REQUEST

Current Zoning: N1-A (neighborhood one)
Proposed Zoning: R-8(CD) (single family residential, conditional)

Approximately 1.77 acres located on the south side of McKee Road, east of Weddington Road, and west of Savannah Hills Drive

The petition proposes to redevelop the existing single family home/lot with a total of 14 units, with two triplexes and two quadruplexes on individual lots for a site in southeast Charlotte.

RZ-1

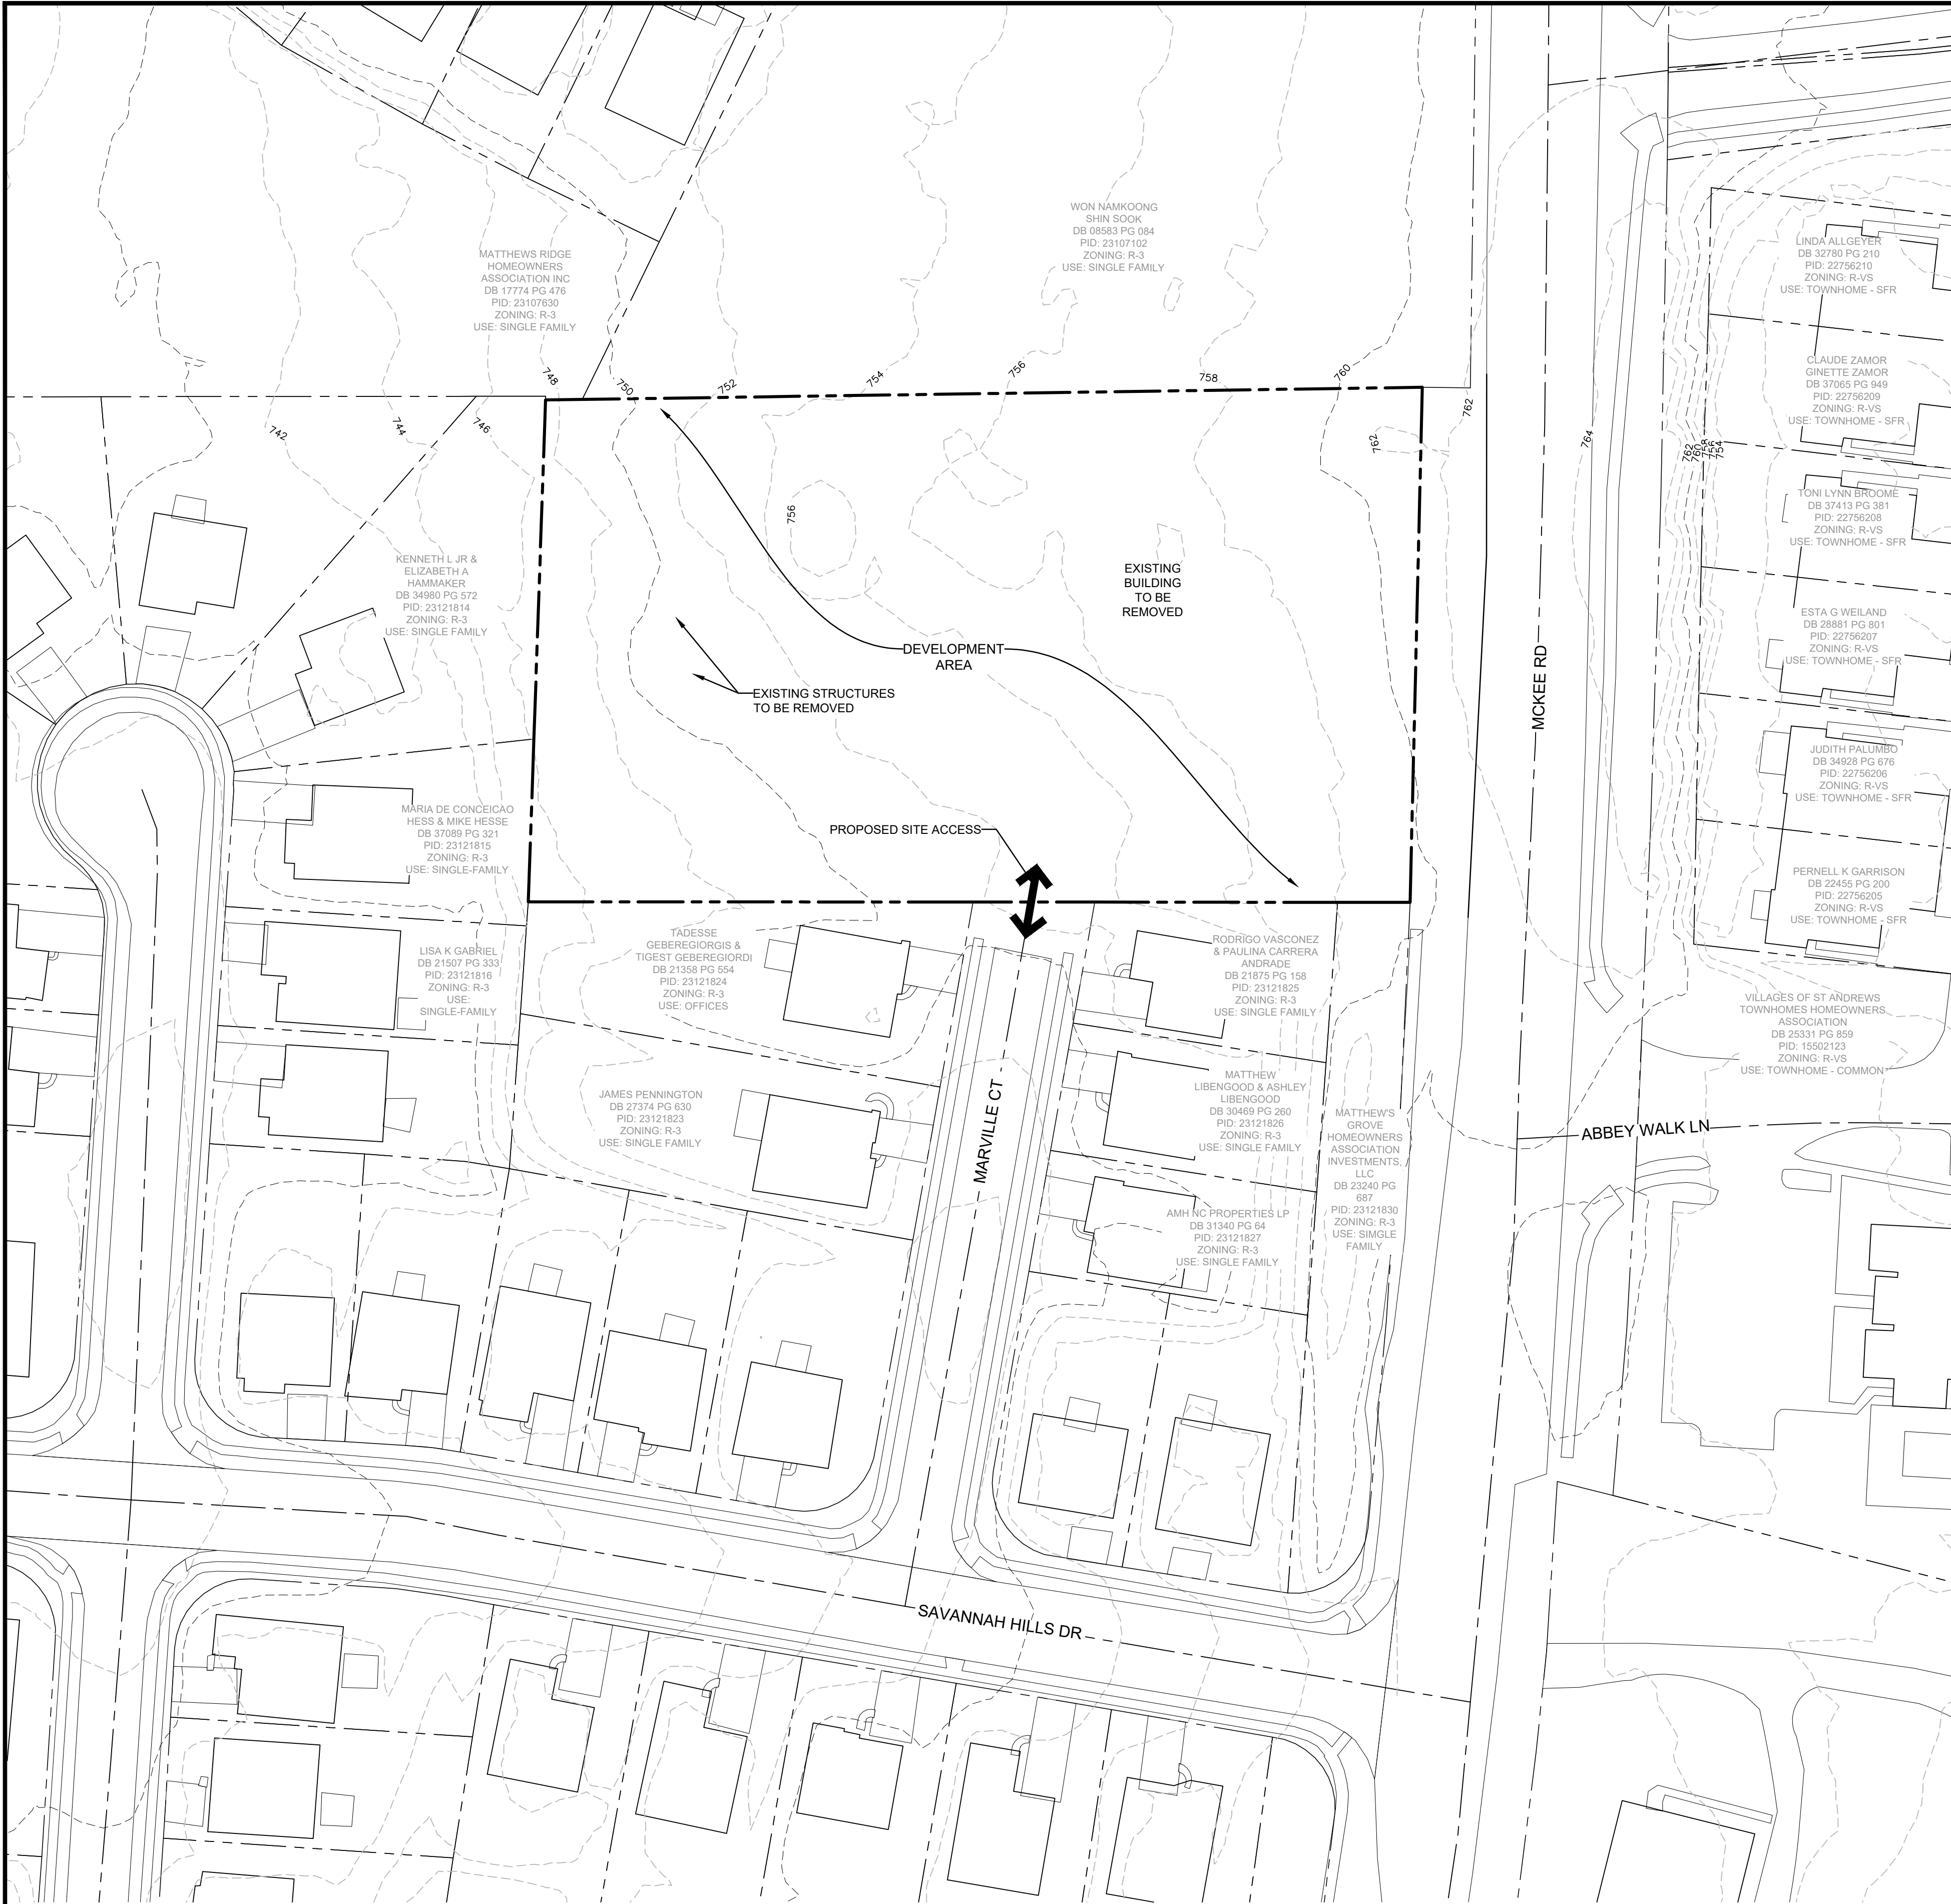
7. Show potential solid waste facilities on the site plan.
 8. The legend includes proposed and existing trees, however none are depicted on the site plan. But note 5.2 references existing trees along the eastern property line.
 9. Delete Architectural note 4.6 as it is repeated and 4.11 as it does not apply.
 10. Update the existing zoning in the development data to reflect N1-A per UDO translation.
-

**REZONING SITE PLAN**

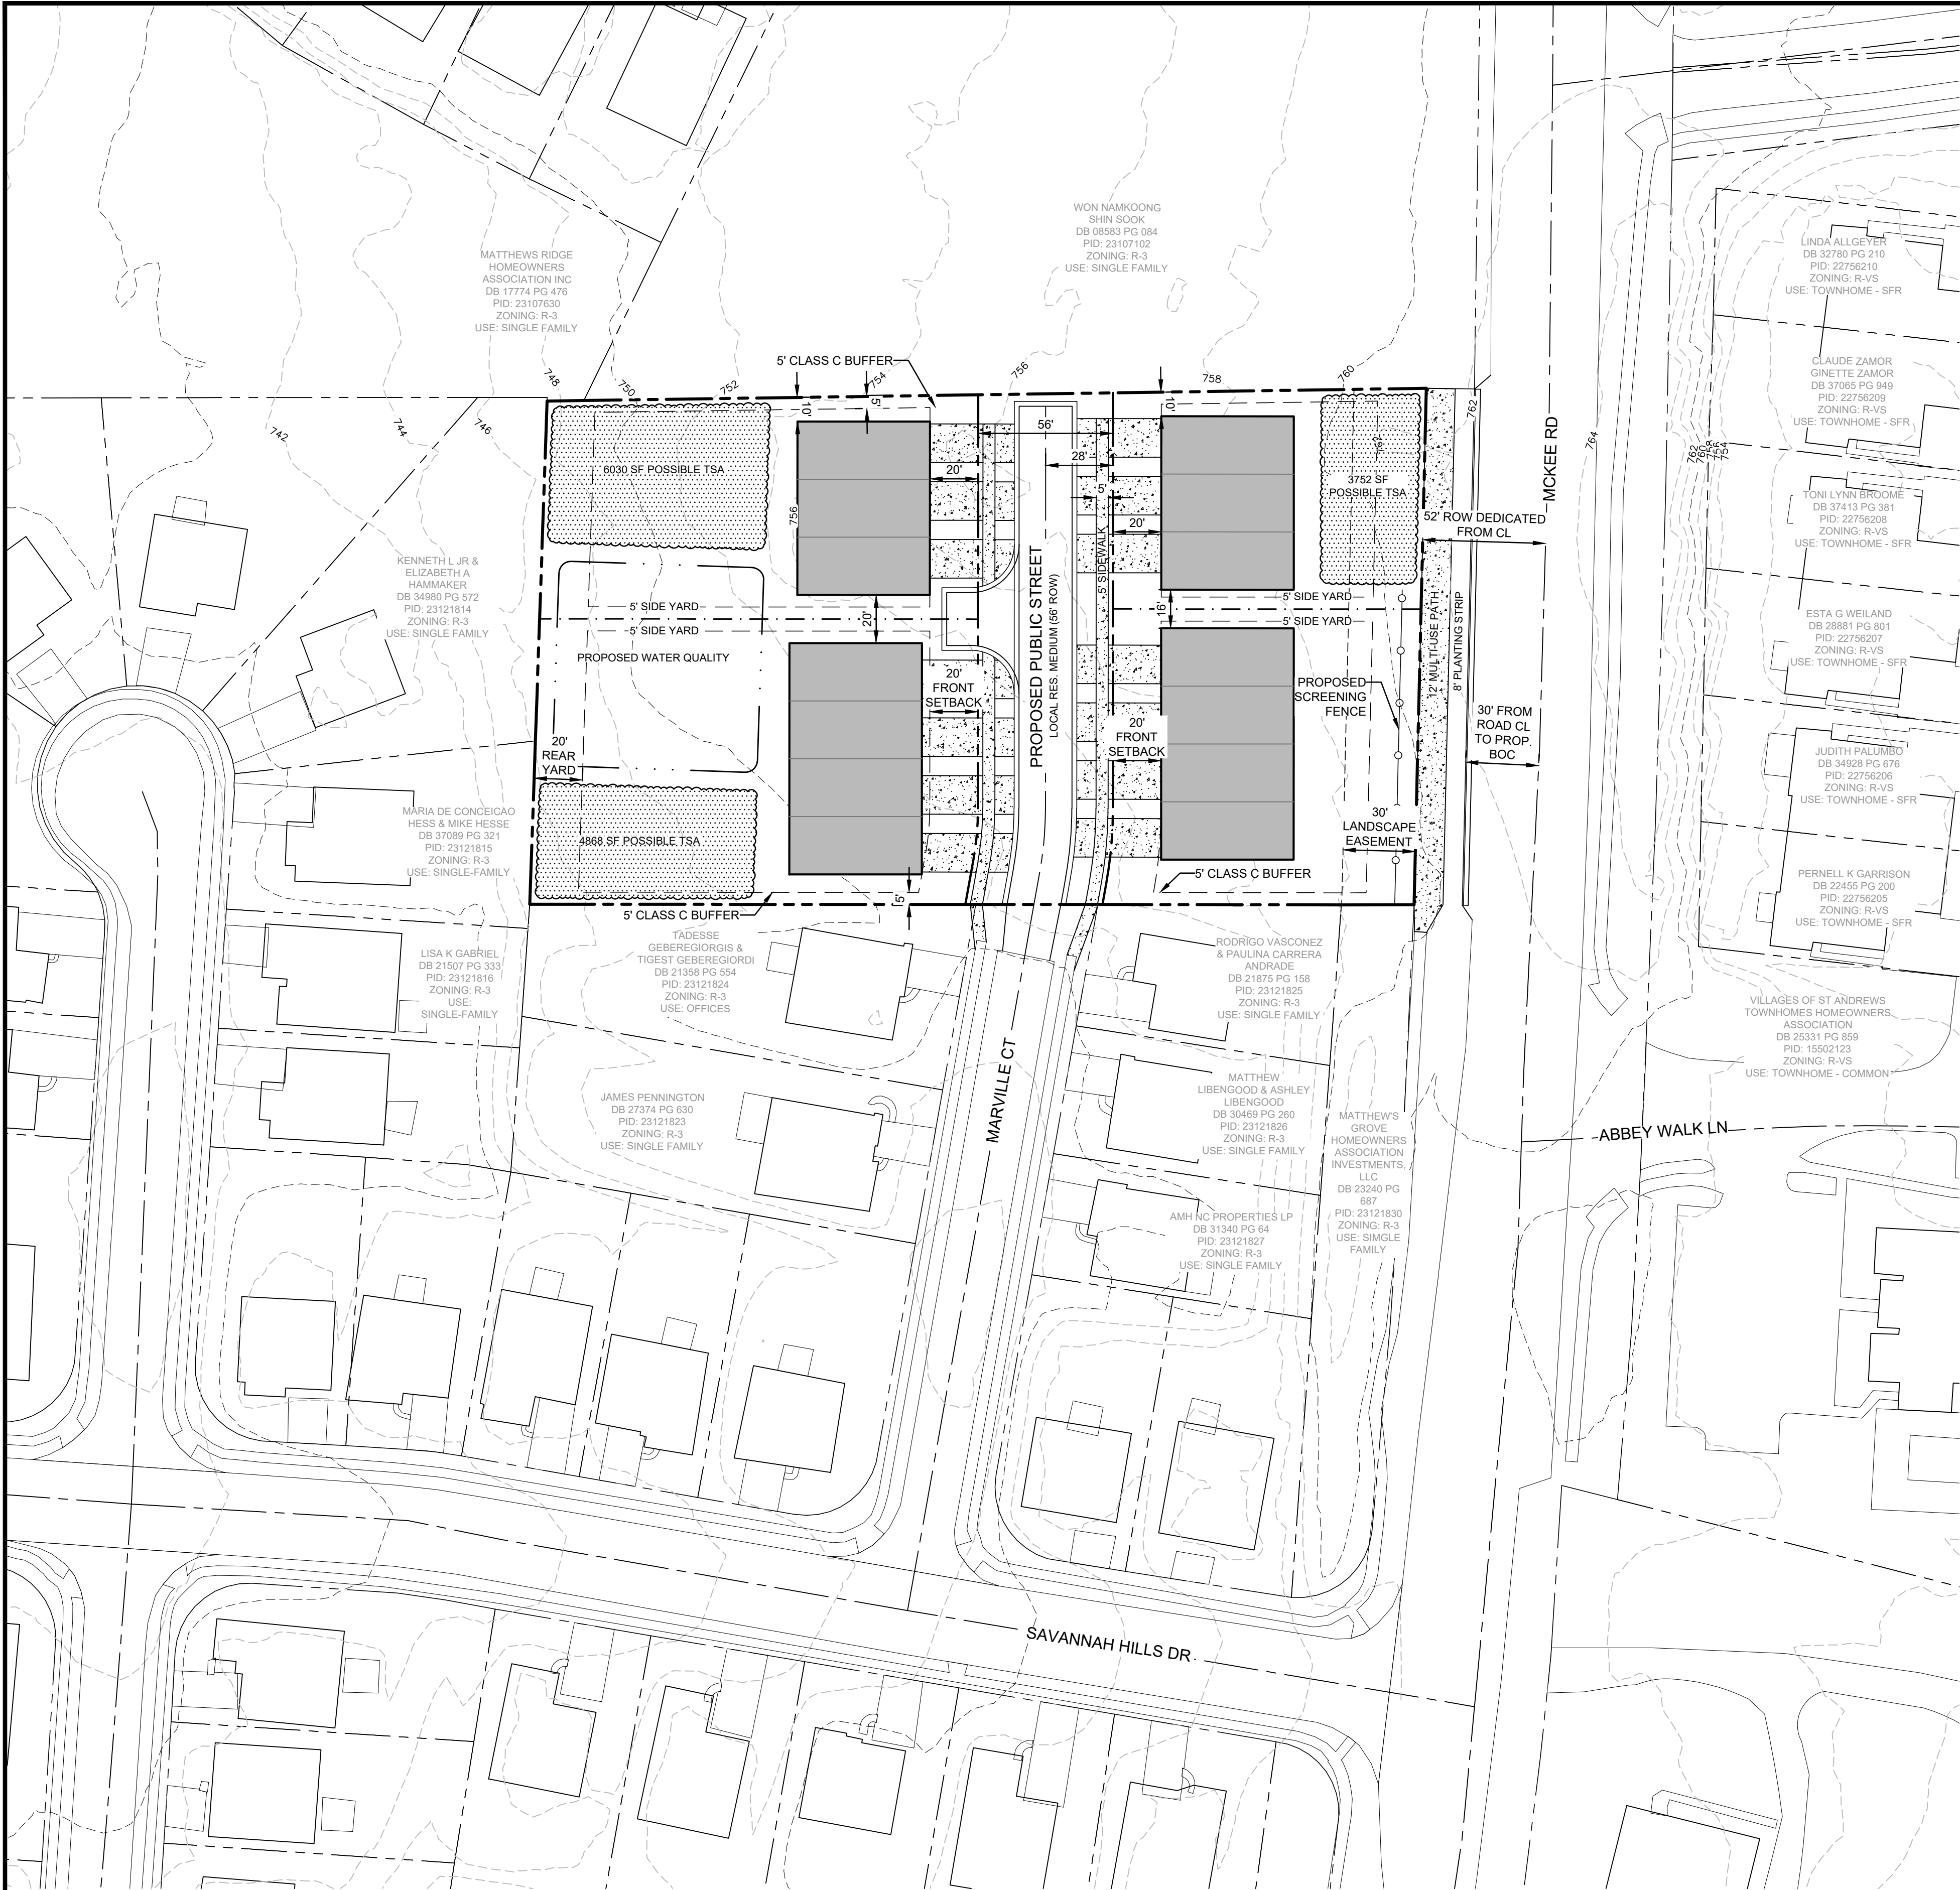
1. Provide a note committing to the treatment of stormwater from including pre-existing impervious surface coverage.
2. Specify proposed stormwater conveyance from proposed water quality facility to existing stormwater infrastructure to minimize impacts to adjacent single family properties.

3. Refine Open space note 5.2 to clarify what is required, show desired tree preservation area on the site plan or provide a minimum width/buffer area of trees that should remain.

4. Verify with Subdivision if 12.308 applies to this development. If so the 20-rear yard is measured from the inside edge of a 30 ft landscape area/common open space.

5. Verify internal side yards shown on plan as they appear larger than 5 ft.
6. Correct inconsistency between the development data table and site plan for front setback. The data table says 30 ft setback from thoroughfare while the plan shows 20 ft. If 12.308 applies, then a 30 ft common open space or landscape easement is required, and a 20 ft rear yard is measured from there.
